RE: Lot #1 Farm House Lane
(ID#2002-0091, CBL# 376-A-051)

In response to drainage concerns, and after meeting with you on site to look at lessening the drainage impacts on neighboring properties, I have the following comments:

Figure No.
3

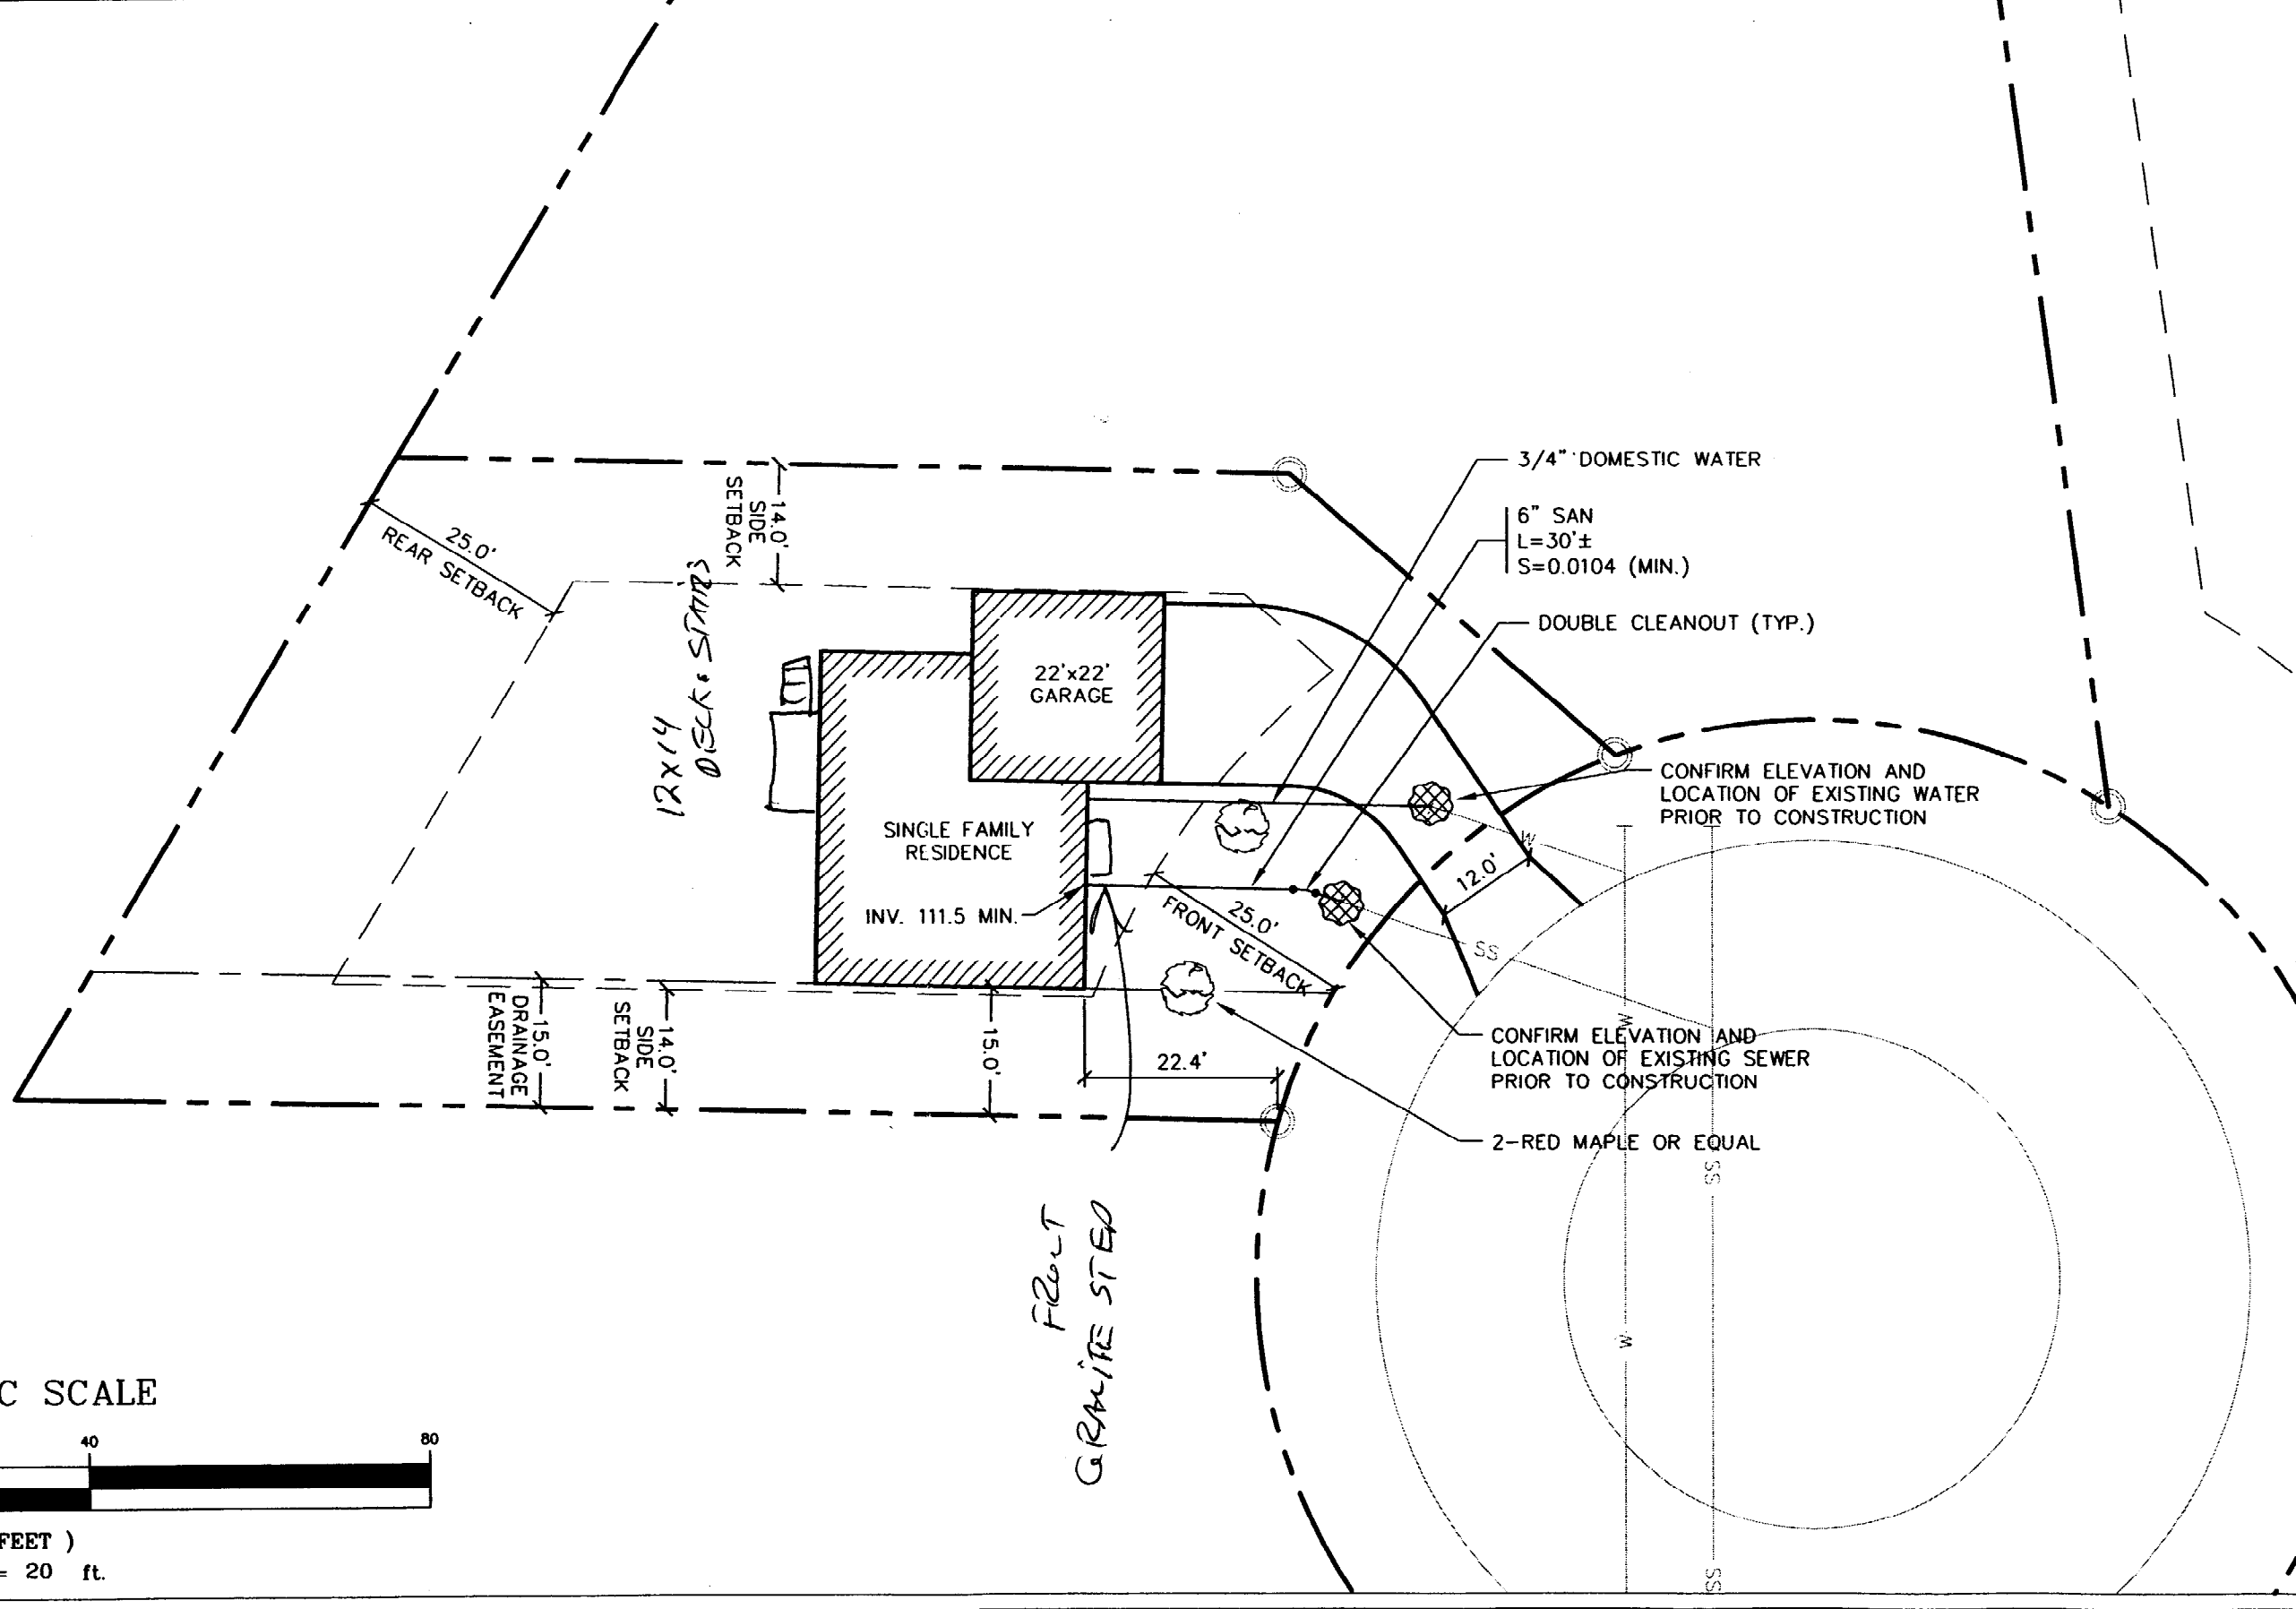
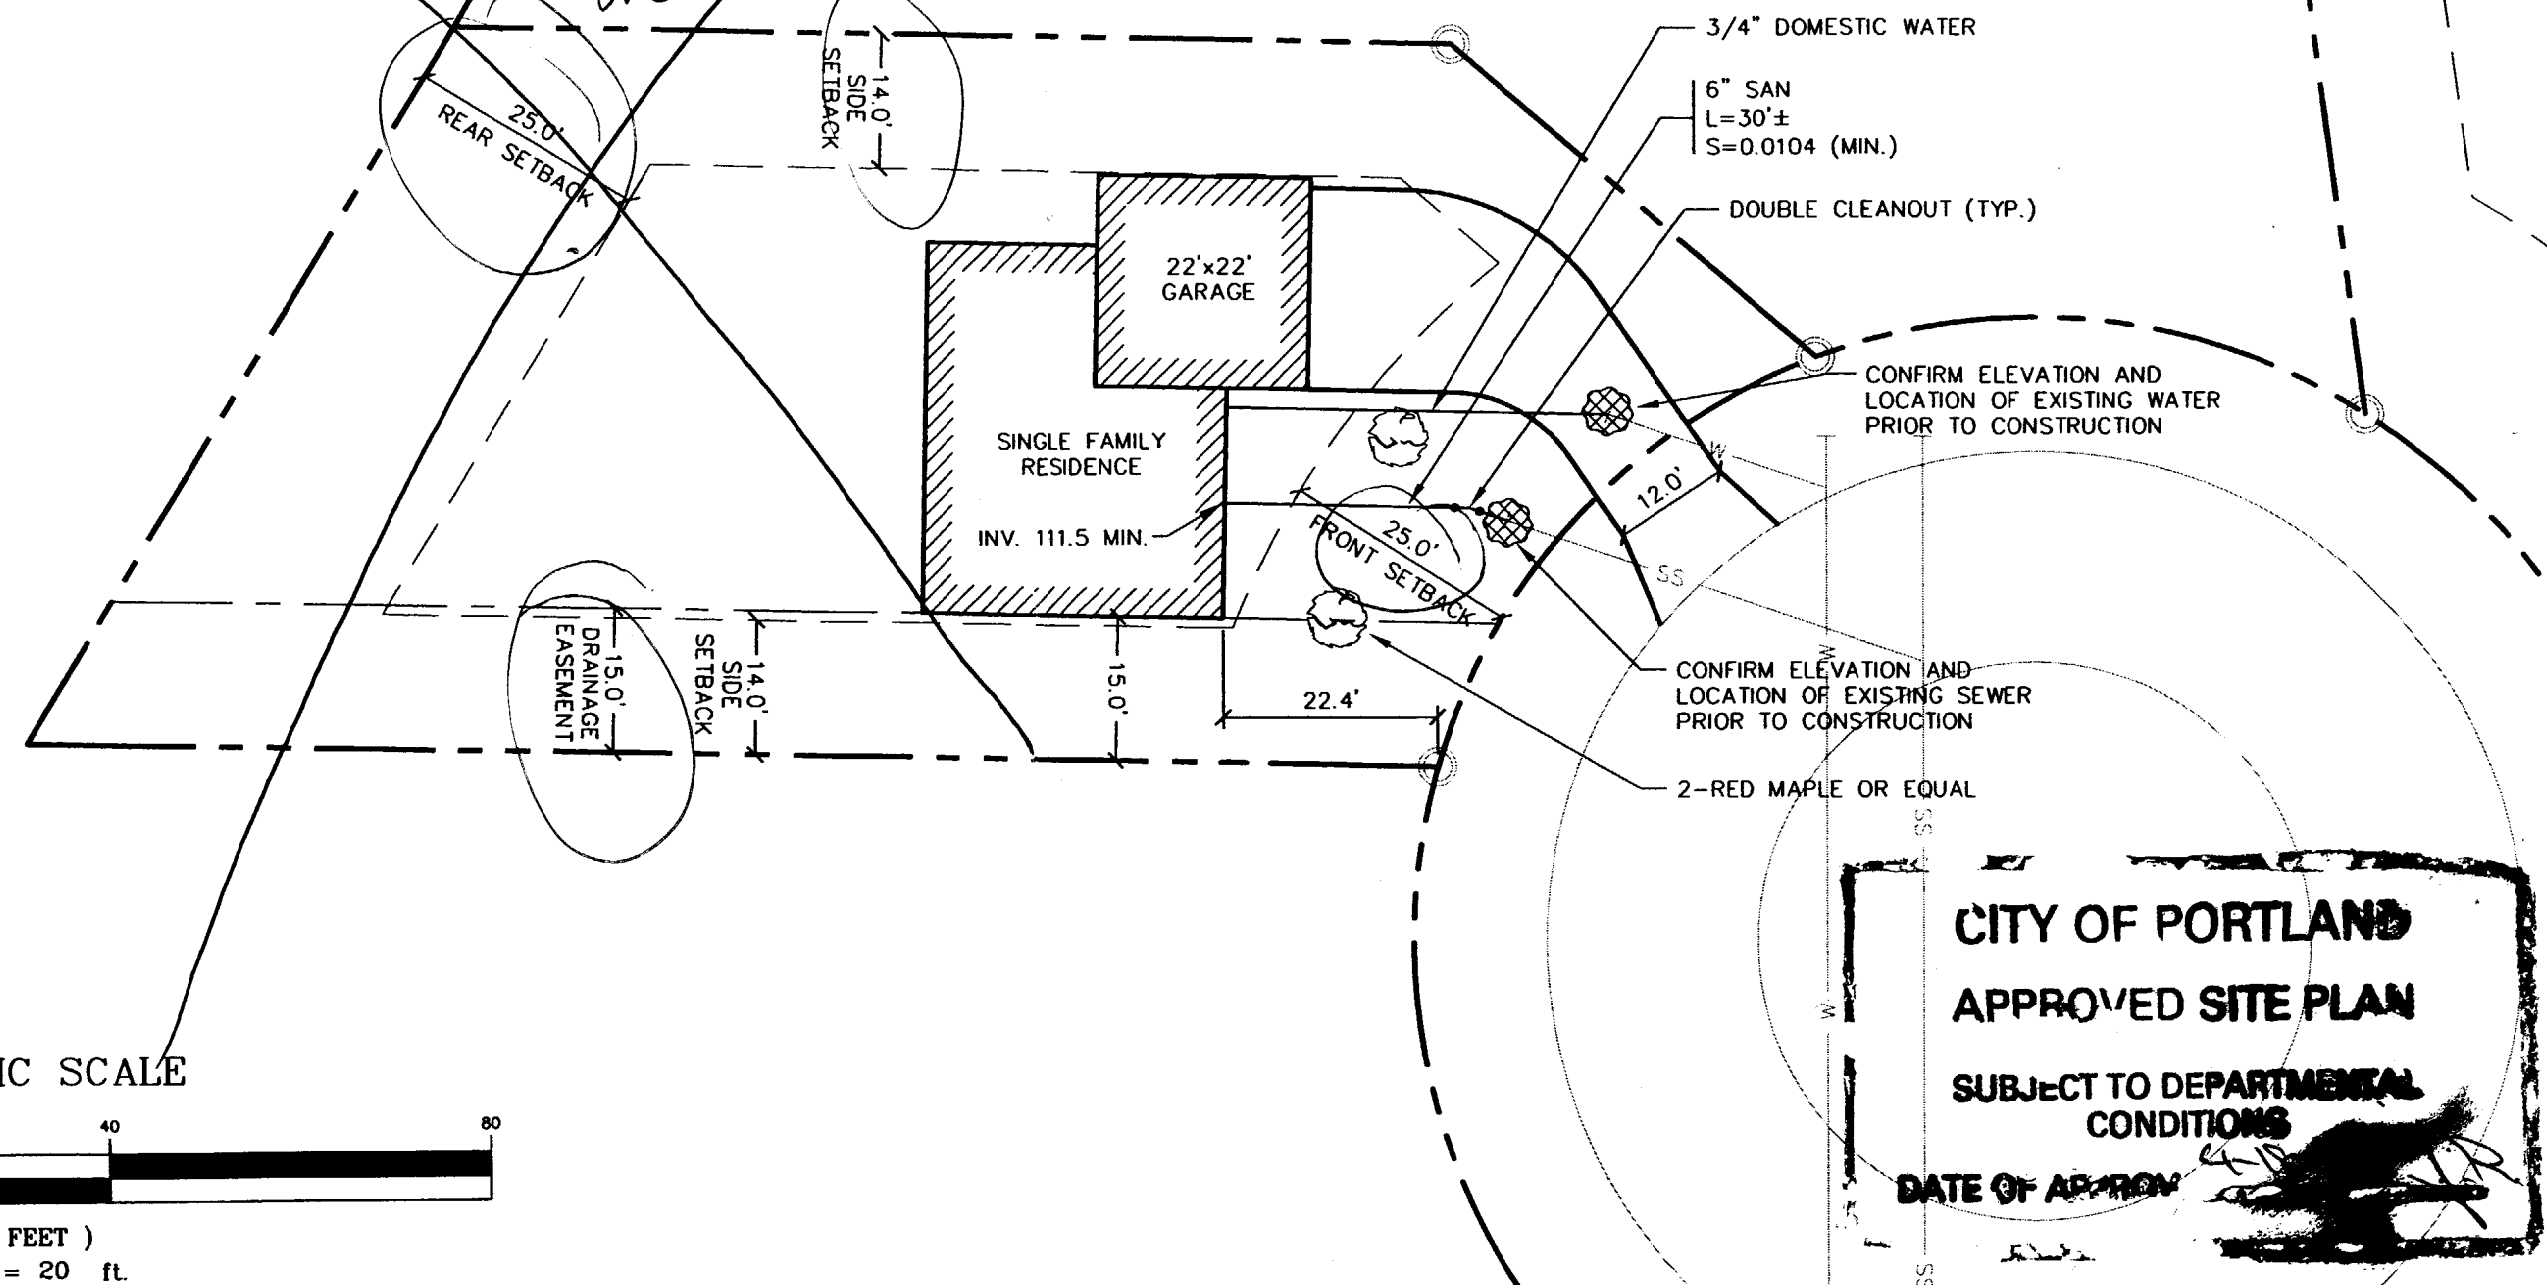
1. A dry well will need to be installed, as we discussed, to collect drainage from the foundation drain from #16 Farm House Lane. The city requests that a detail for the dry well be submitted for review (please send to my attention).
2. Grading in the front of the building will be done so that as much drainage as possible will be conveyed towards Farm House Lane.
3. What little grading is proposed in the rear of the building shall be done so that drainage is directed towards the dry well.

1. As requested, Les Wilson and Sons, Inc., to collect drainage from the foundation drain from #16 Farm House Lane, have installed the dry well.
2. As you conveyed to me on site, the details for the dry well are as follows:
 - a. Approximately 6 feet in diameter.
 - b. 3 to 4 feet in depth.
 - c. Filter fabric installed around the perimeter and below the dry well, as specified.
 - d. 1/2" to 3/4" crushed stone installed.
3. Proposed grading in the rear of the building has been done so that drainage is directed towards the dry well.
